February 12, 2004

Harnett County Government Complex
307 Cornelius Harnett Boulevard
Lillington, NC 27546

Re: Application for improvement permit for Hwy. 210
Health Department file No. 05-5-8597

SOIL/SITE EVALUATION for ON-SITE WASTEWATER SYSTEM

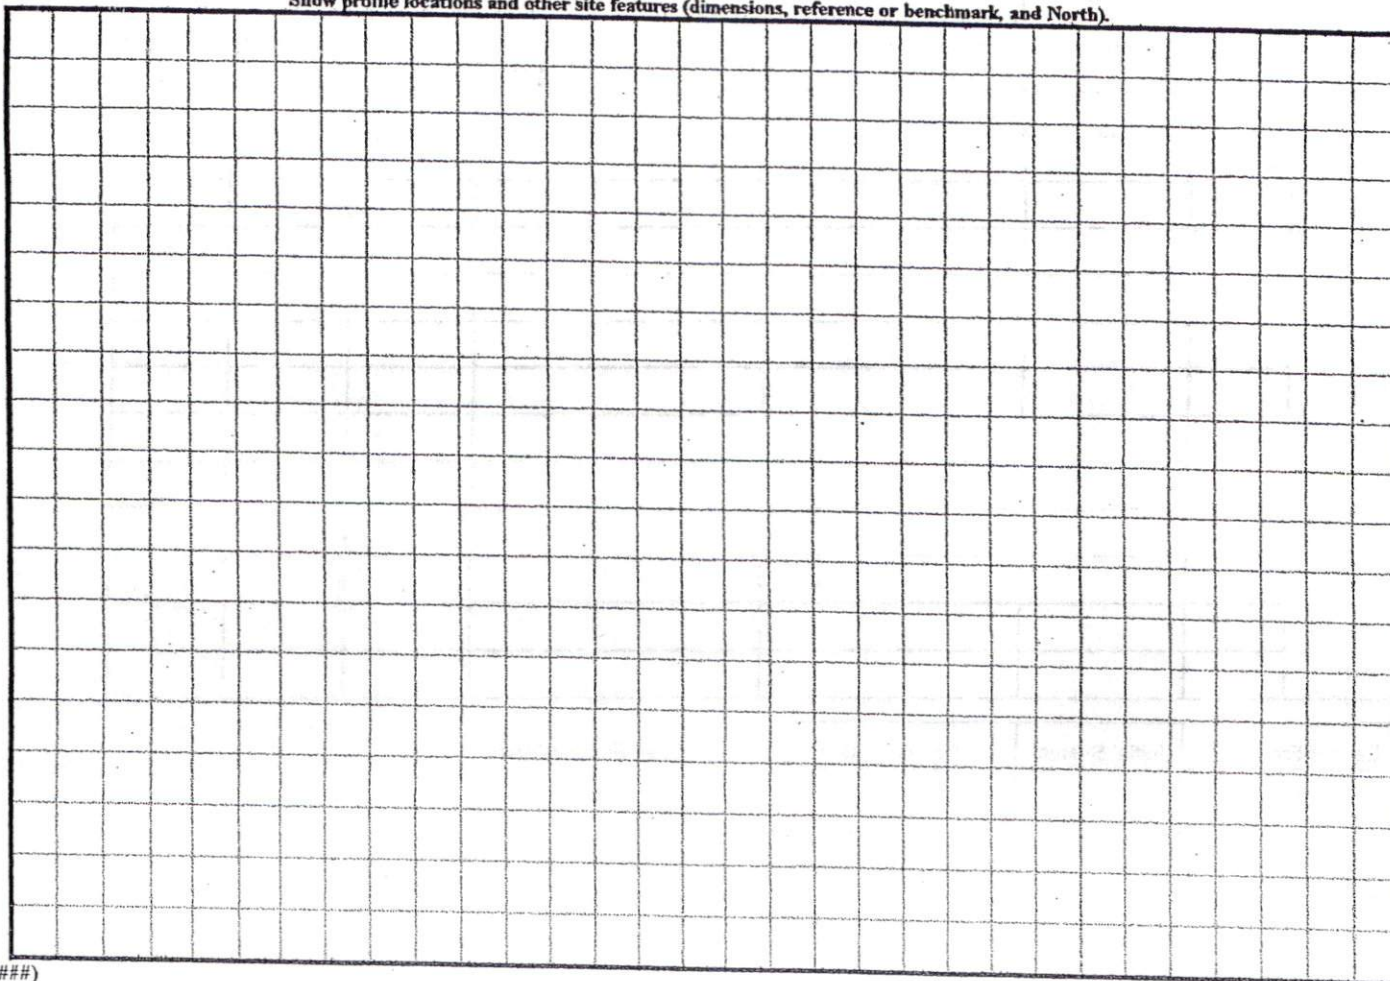
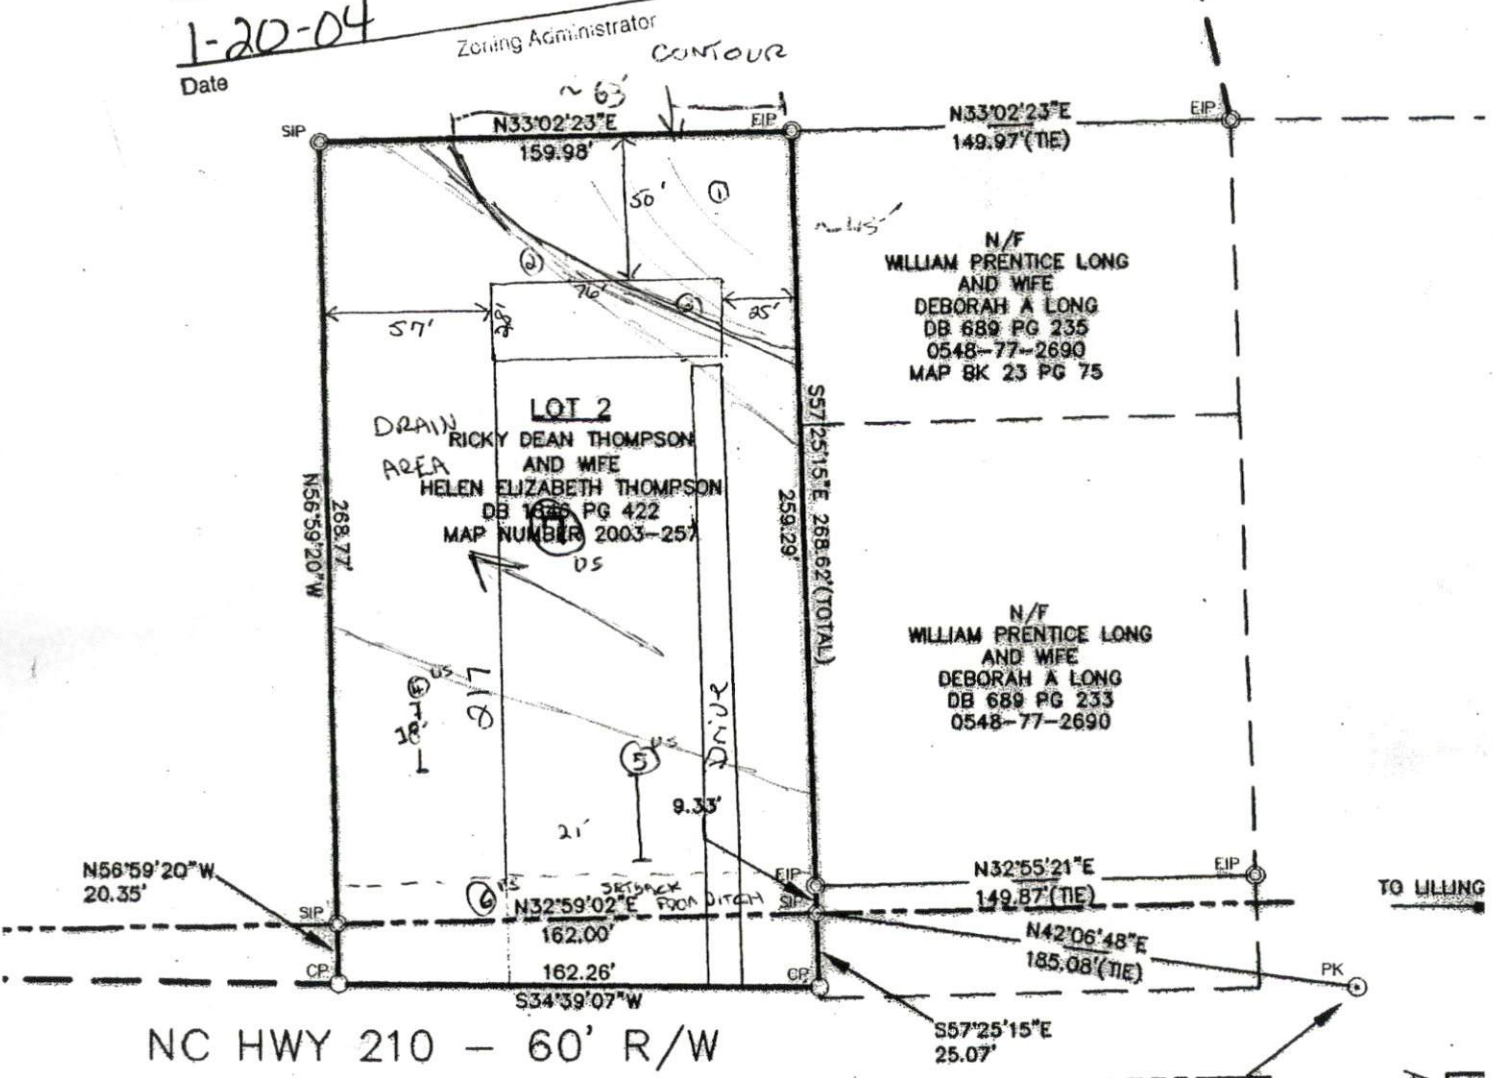
Based on the criteria set out in Title 15A, Subchapter 18A, of the North Carolina Administrative Code, Rules .1940 through .1948, the evaluation indicated that the site is **UNSUITABLE** for a ground absorption sewage system. Therefore, your request for an improvement permit is **DENIED**. A copy of the site evaluation is enclosed. The site is unsuitable based on the following:

- ☒ Unsuitable soil topography and/or landscape position (Rule .1940)
- ☐ Unsuitable soil characteristics (structure or clay mineralogy) (Rule .1941)
- ☒ Unsuitable soil wetness condition (Rule .1942)
- ☒ Unsuitable soil depth (Rule .1943)
- ☐ Presence of restrictive horizon (Rule .1944)
- ☒ Insufficient space for septic system and repair area (Rule .1945)
- ☐ Unsuitable for meeting required setbacks (Rule .1950)
- ☐ Other (Rule .1946) _____

The site evaluation included consideration of possible site modifications, and modified, innovative or alternative systems. However, the Health Department has determined that none of the above options will overcome the severe conditions on this site. A possible option might be a system designed to dispose of sewage to another area of suitable soil or off-site to additional property.

However, the site classified as **UNSUITABLE** may be classified as **PROVISIONALLY SUITABLE** if written documentation is provided that meets the requirements of Rule .1948(d). A copy of this rule is enclosed. You may hire a consultant to assist you if you wish to try to develop a plan under which your site could be reclassified as **PROVISIONALLY SUITABLE**.
